**FORMAL REPRESENTATION: OBJECTION TO PLANNING APPLICATION
2026/91923 Land at St Luke's, Bierley Marsh, East Bierley, BD4 6PL Objection
regarding the factual inaccuracy and invalidity of submitted Plan 19.157.104J**

I am writing to submit a further formal objection to planning application **2026/91923**, which seeks a Section 73 variation of Condition 2 (approved plans) of planning permission **2020/94345** (allowed on appeal, ref. APP/Z4718/W/21/3289729). In introducing solar panels, the developer has submitted site layout Plan **19.157.104J**.

client name Owens Developments Ltd			
project New Dwellings - Land at St Lukes.			
drawing Proposed Site Layout			
project number 19/157	plot date 24/11/20	scale 1:200	@A2
drawing number 104	rev B	issue status Planning Submission

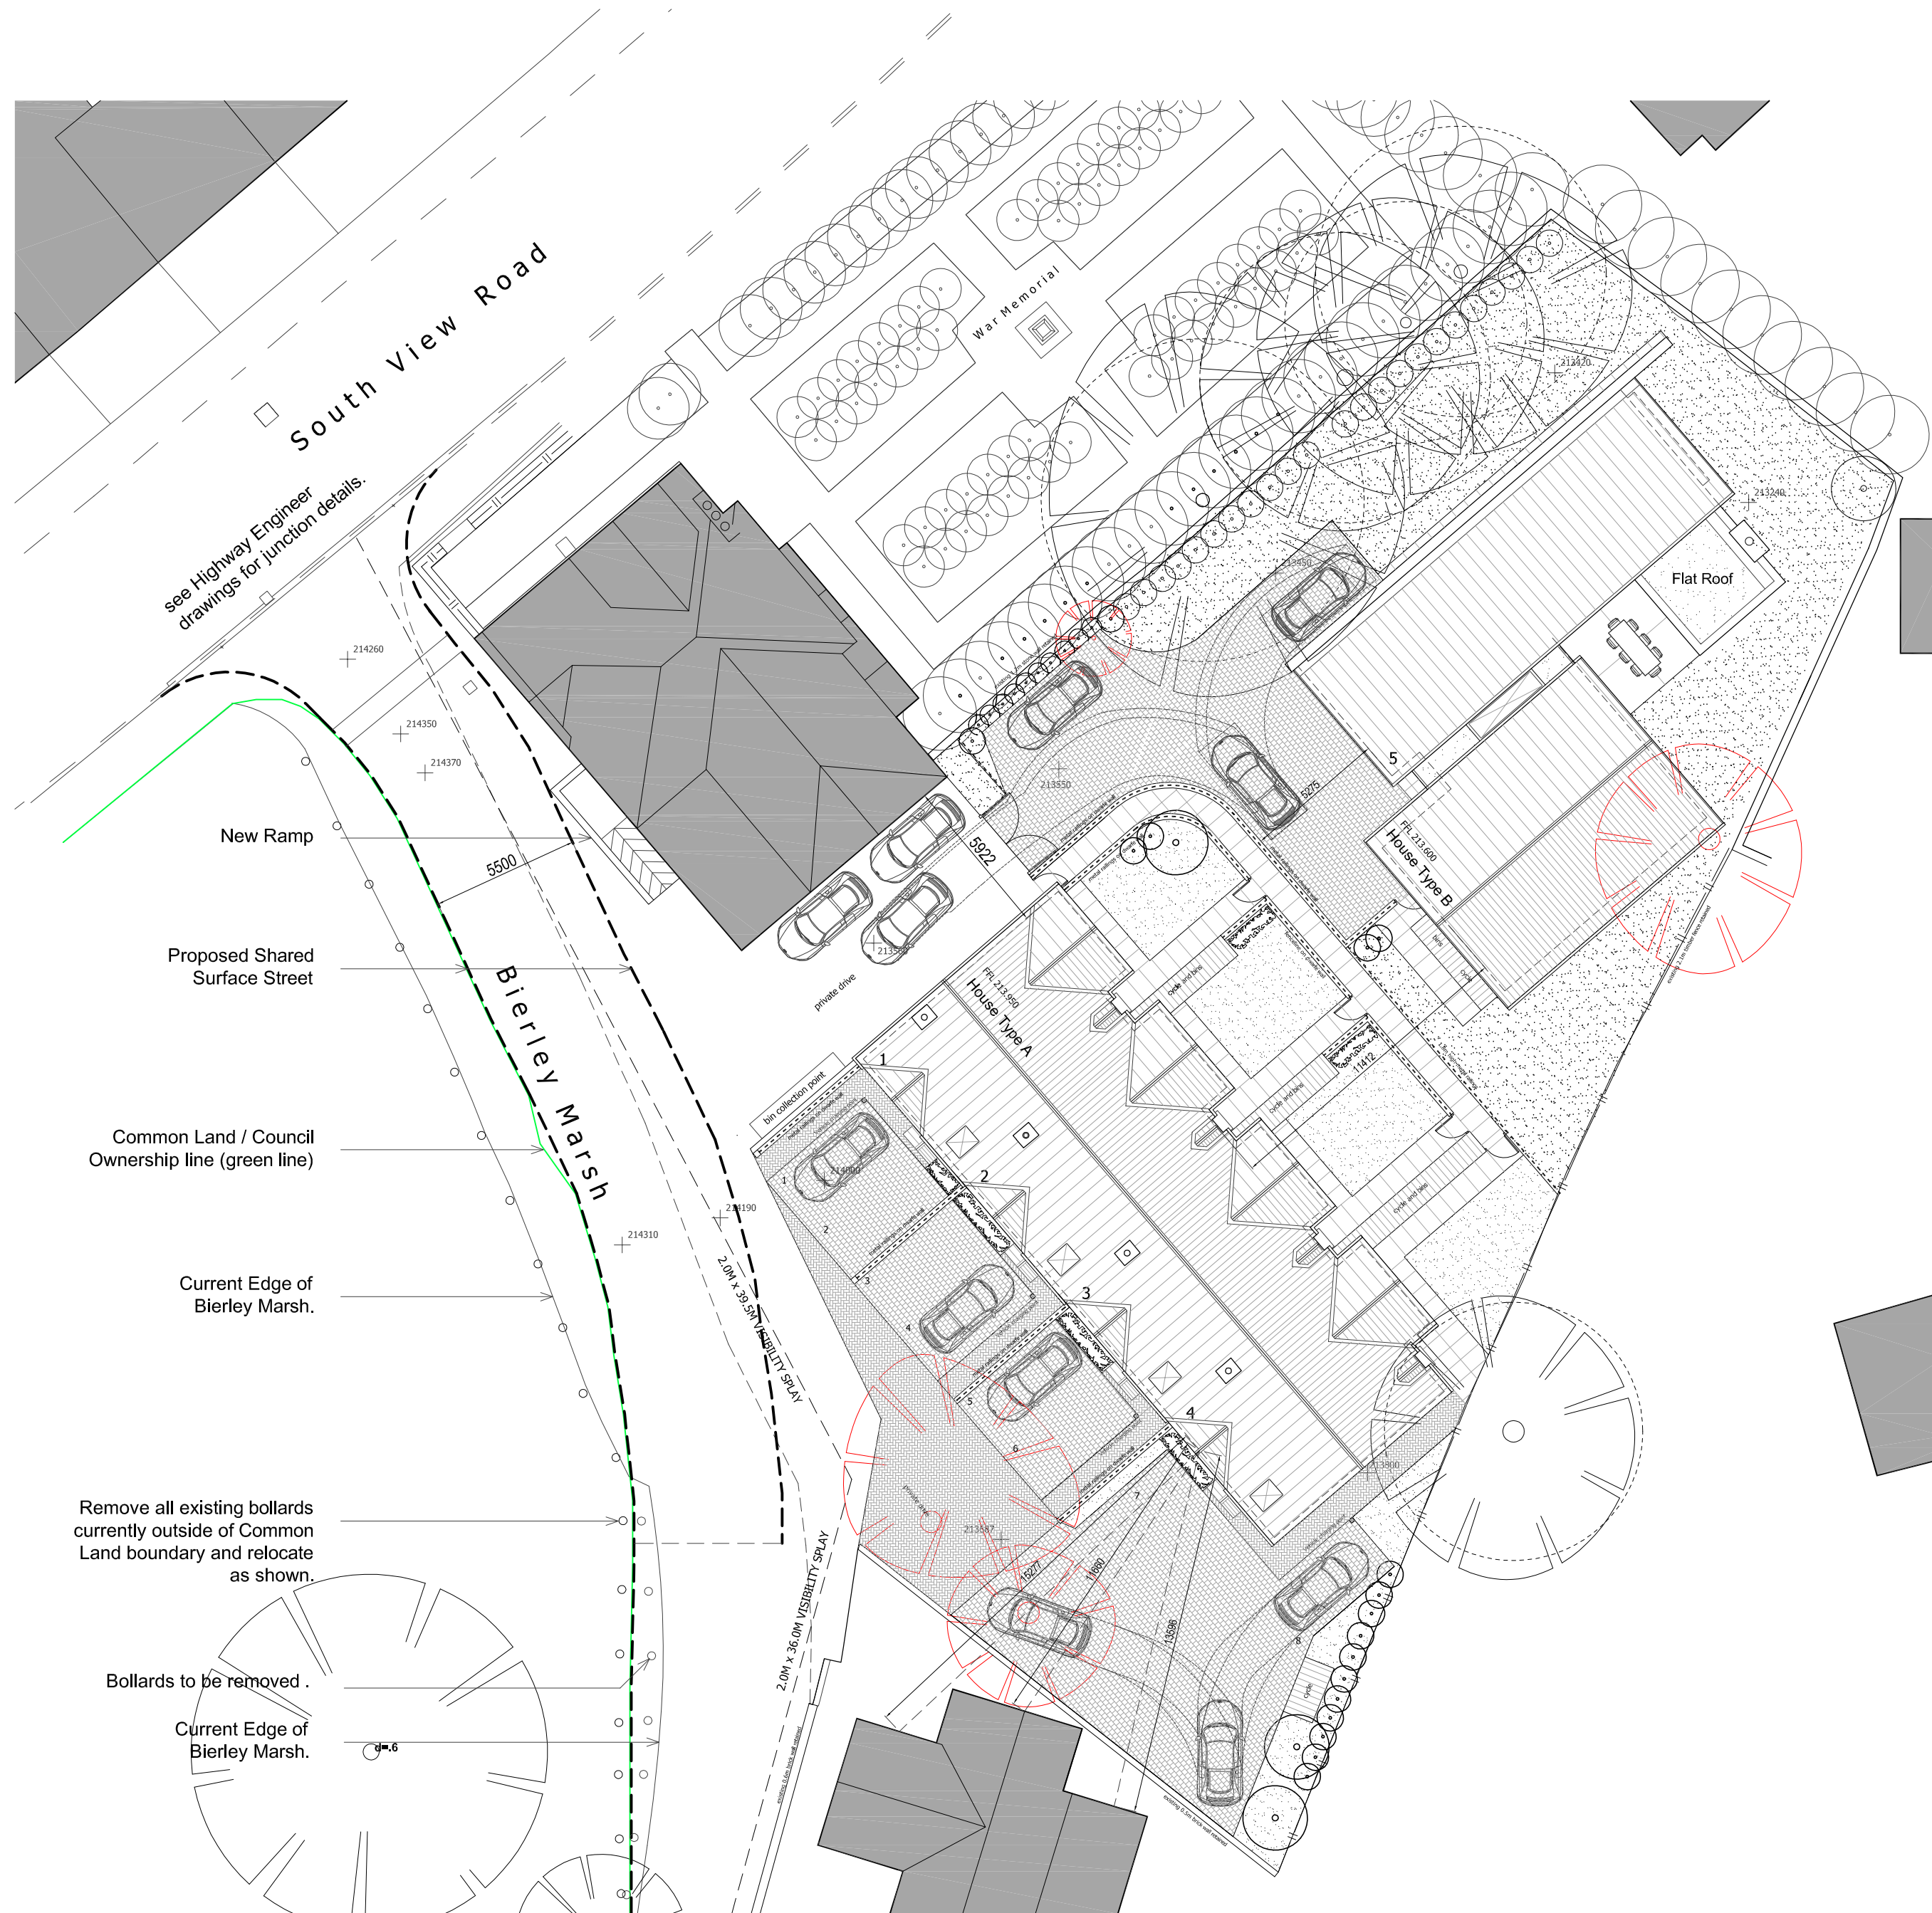
It is unclear why the developer has submitted the now-superseded drawing **19.157.104B** with this application.

Plan 19.157.104B, extract below, contains explicit annotations proposing the removal and relocation of existing protective steel bollards protecting the Common adjacent to the boundary with Bierley Marsh:

These bollards, lie entirely outside the developer's red-line boundary. They are historical boundary markers installed by Kirklees Council to protect the common land from vehicular encroachment.

It may be that the developer is not proposing again o re-site these bollards, however, any physical works or alterations to these bollards by the developer would constitute an unauthorised intervention on land outside their control, representing a material defect that invalidates the scope of the application.

I ask that Kirklees take positive action to stop the developer re-siting these bollards if that is the developers intention.

client name		Owens Developments Ltd	
project		New Dwellings - Land at St Lukes.	
drawing		Proposed Site Layout	
project number	19/157		plot date
			24/11/20
drawing number	104		scale
			1:200 @A2
drawing number	rev	issue status	
	J	Planning Submission

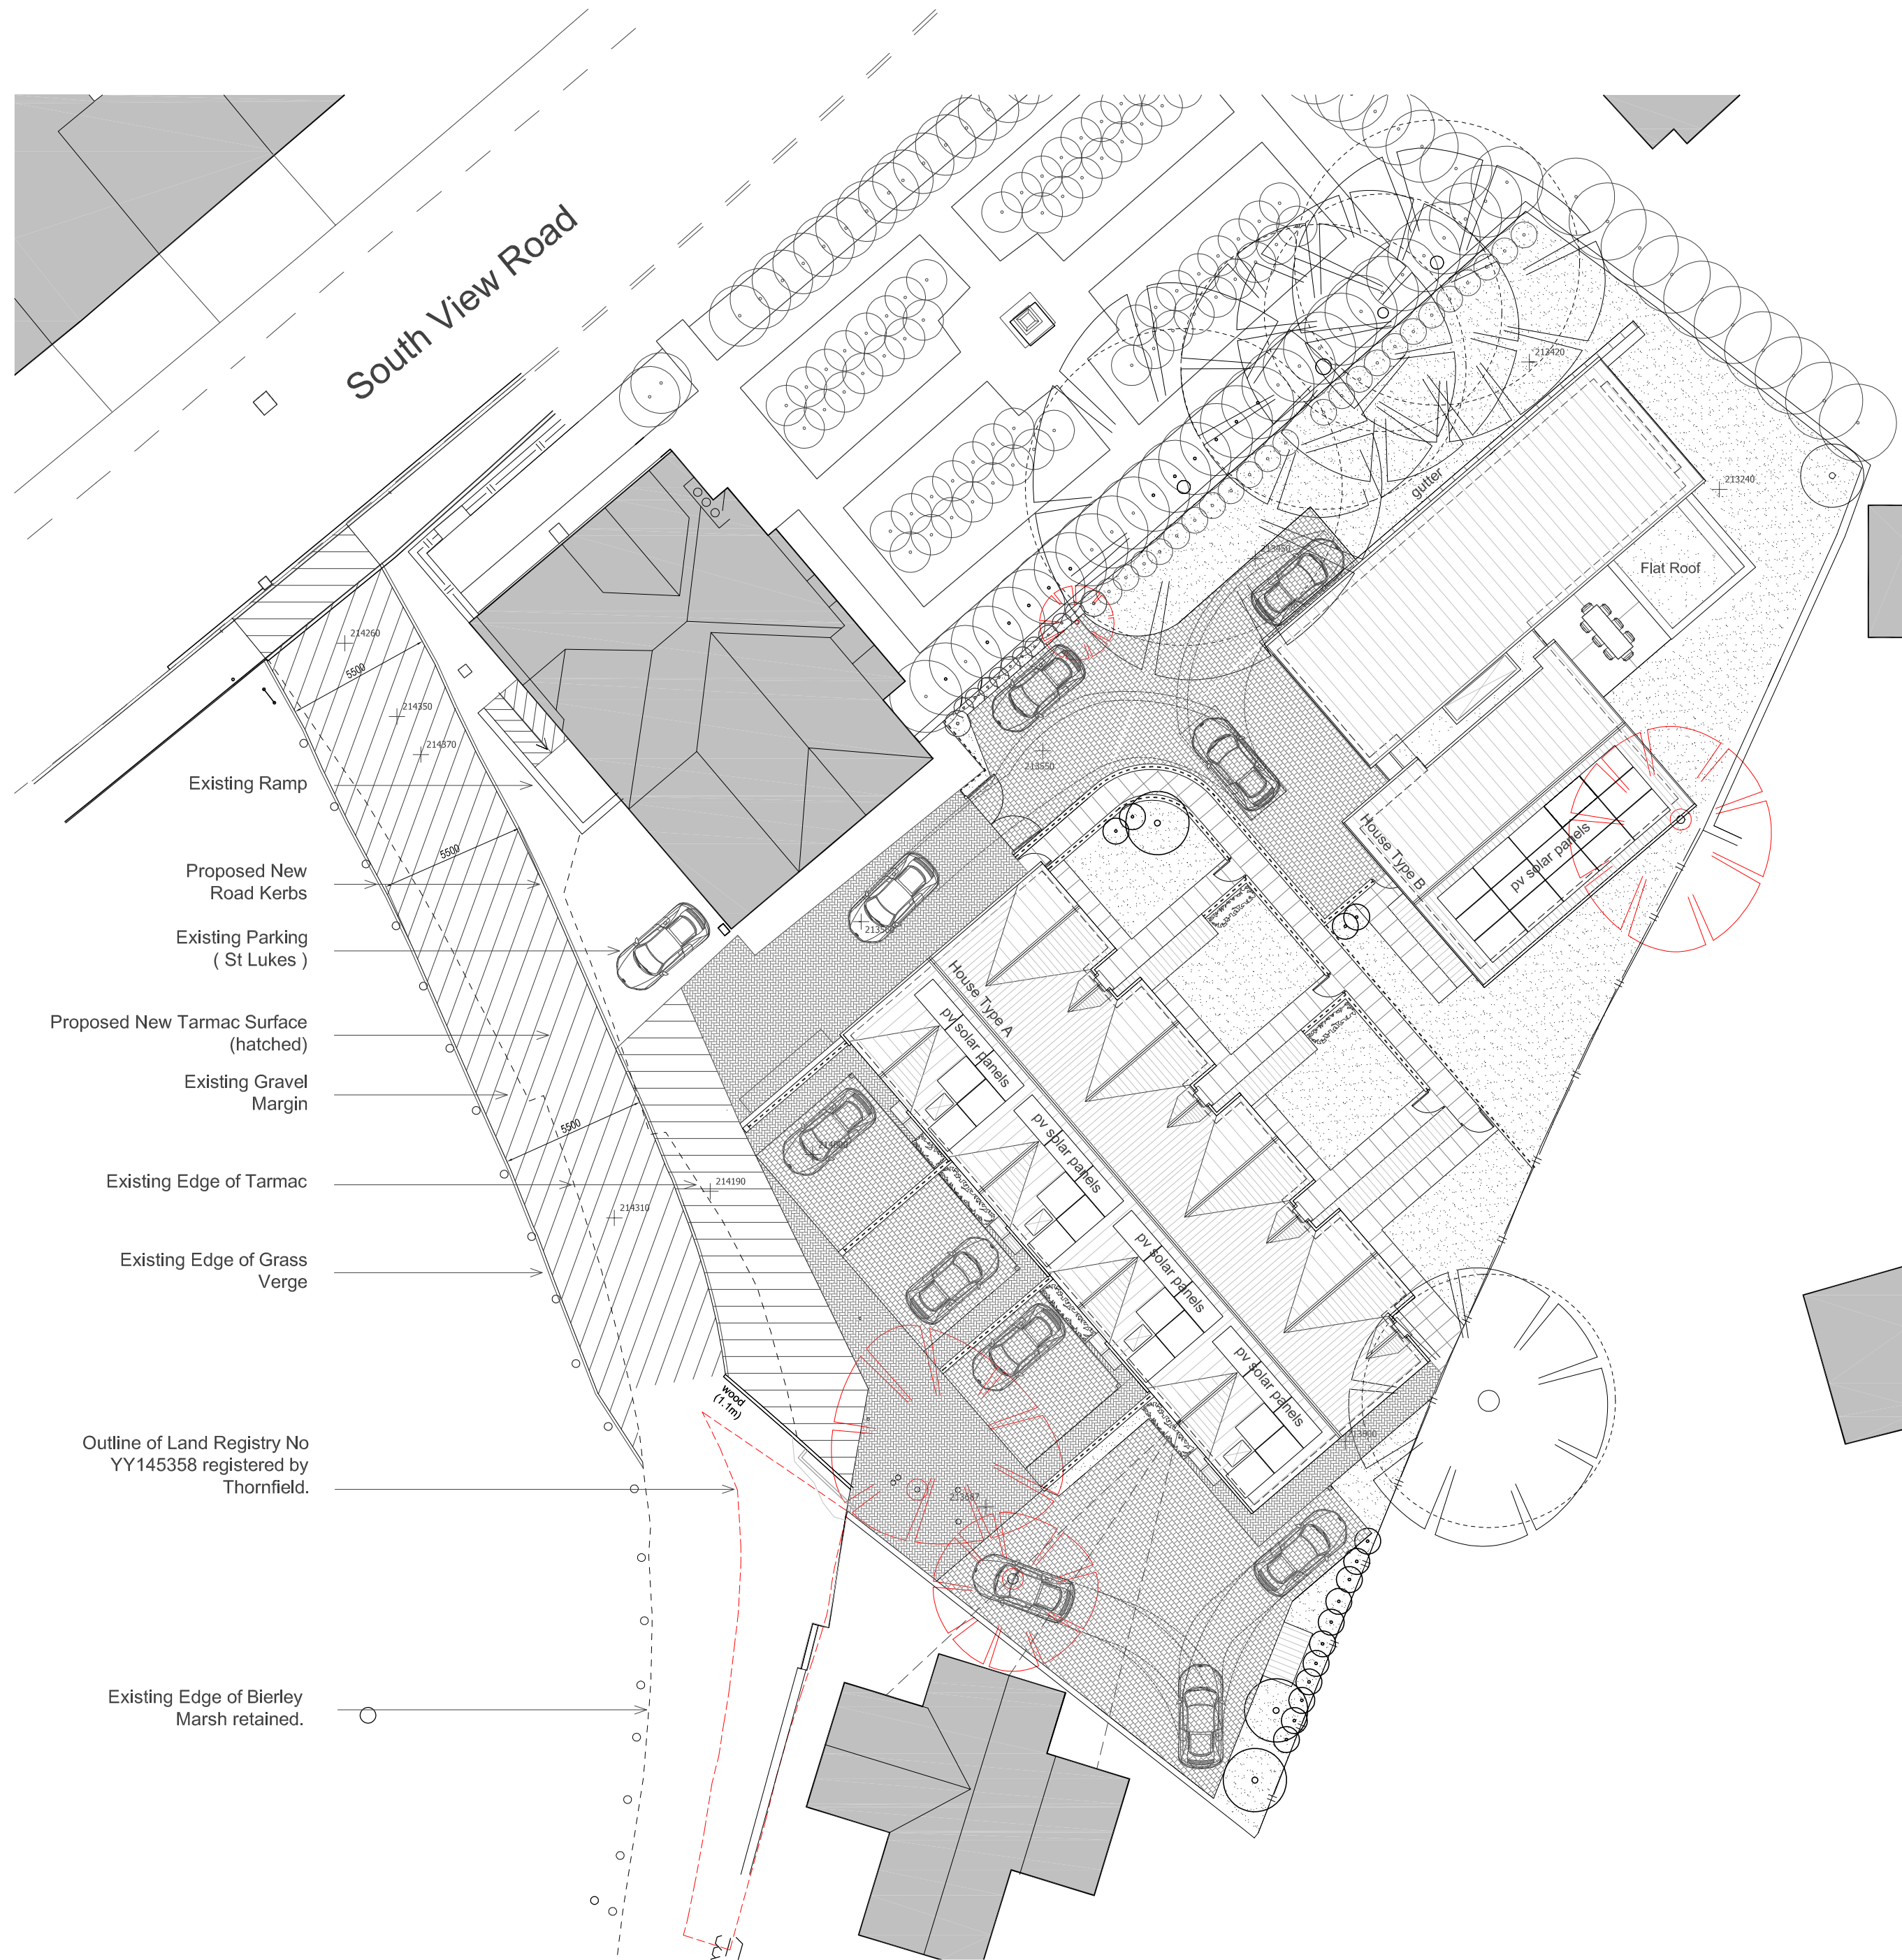
The developer's submitted site plan (**19.157.104J**) does not accurately reflect the physical position of my former timber boundary fence (historically aligned with the brick wall of my property, Thornfield), nor does it correctly illustrate the developer's new timber (boundary) fenceline now erected on-site (shown blue above).

The discrepancy on Plan 19.157.104J is further highlighted when comparing the plan with the developers Access-Resurfacing Plan (drawing MCB-24-018), which details the boundary alignment with a much higher degree of physical accuracy in relation to the actual position on the ground.

By failing to accurately represent the physical site boundaries and the actual relationship of the new fencelines to Thornfield, the developer's Plan **19.157.104J** creates an inconsistent, inaccurate, and contradictory planning record that prevents the Local Planning Authority from safely assessing boundary treatment compliance under Condition 33.

- The drawings completely fail to identify the statutory bin storage and presentation locations required under planning guidelines.
- The layout fails to illustrate the mandatory 0.6m hard margins required on either side of the 5.5m shared street, violating Section 1.7 of the Highways Design SPD.

Plan **19.157.104J** refers to **Note D**, which references a **"Hatched Area of Existing Track added."** This description is factually incorrect and creates a materially inaccurate impression of the site.

The "hatched area", in part only, is over the private street Bierley Marsh; it is also partly over land as repaired registered common land **CL222**. Historically, the East Bierley Village Preservation Society, with the support of Kirklees Council, placed loose stone on this area of the Common to prevent soil erosion, with placement of offset plastic bollards:

In the absence of a verified right of access, the layout shown on Plan 19.157.104J would appear legally undeliverable.

1. **Refuse to accept or determine** the current variation application based on the factually incorrect and contradictory Plan 19.157.104J.
2. **Require the developer** to submit an accurate, verified on-the-ground survey of the physical fencelines to ensure full alignment with drawing MCB-24-018 and Condition 33.
3. **Formally verify the developers private vehicular access rights over public footpath SPE 6-20/30, to** ensure works shown on Plan 19.157.104J are lawful.
4. **Require the developer** to enforce protective buffer zones around the registered utility easements of Thornfield to safeguard our active underground services.
5. **Publish this representation in full** on the public Planning Portal, redacting only private contact details, in accordance with Kirklees Council's public involvement guidelines.
